**Addendum No. 1**

RE: Contract ID C203531  
WBS # 10CR.10901.37, Etc.  
State Funded

**Union County**

2 Section of NC-207, 1 Section of NC-601 &  
10 Sections of Secondary Roads

PROJECT NO.	SHEET NO.	TOTAL NO.
10CR.10901.37, ETC.	15	
10CR.20901.94, ETC.

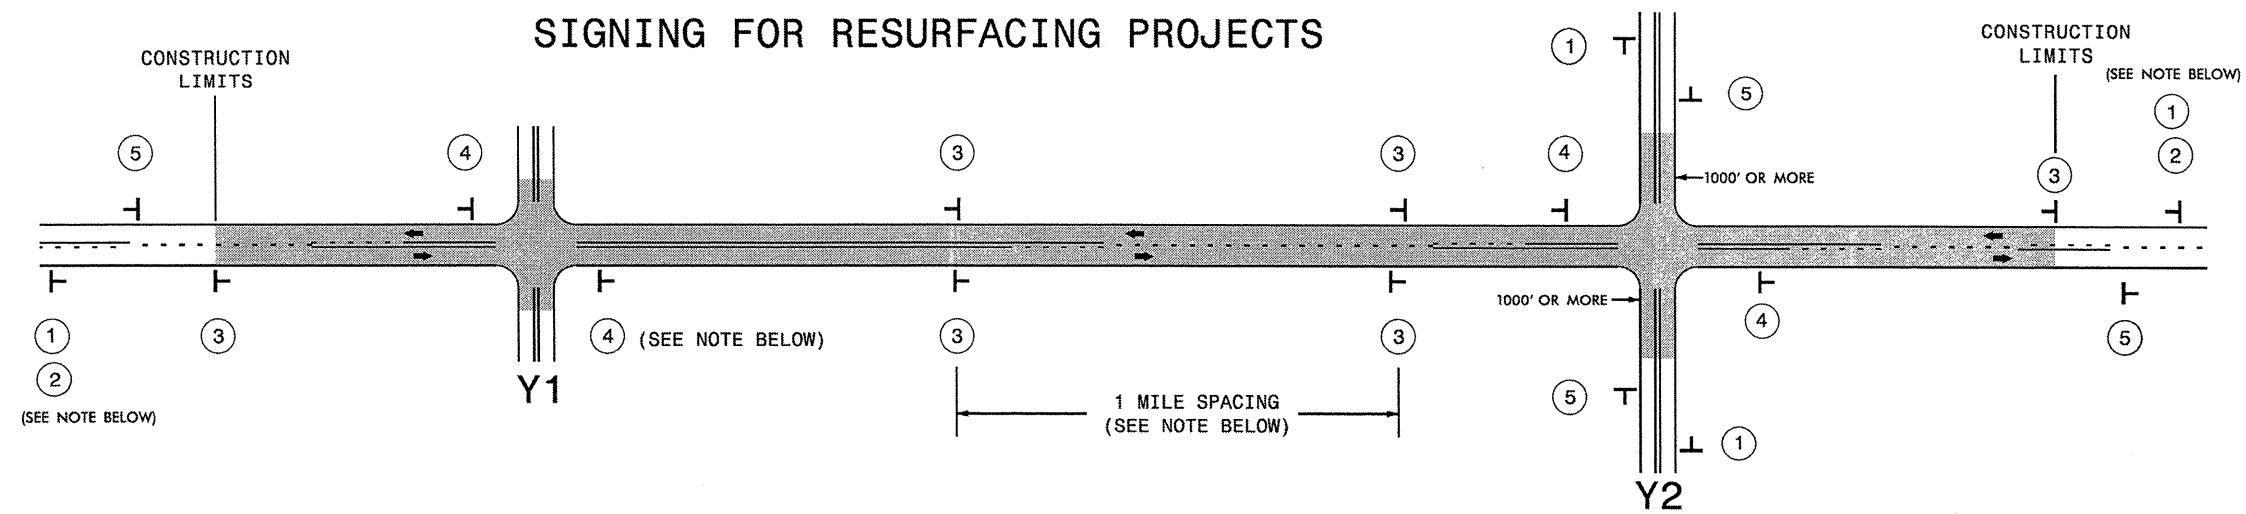
On Sheet Nos. 14 and 15 the 'Summary of Quantities' has been revised to reflect adding the work required for New Map Nos. 14 thru 19. Please void Sheet Nos. 14 and 15 in your sketch maps and staple the revised Sheet Nos. 14 and 15 thereto.
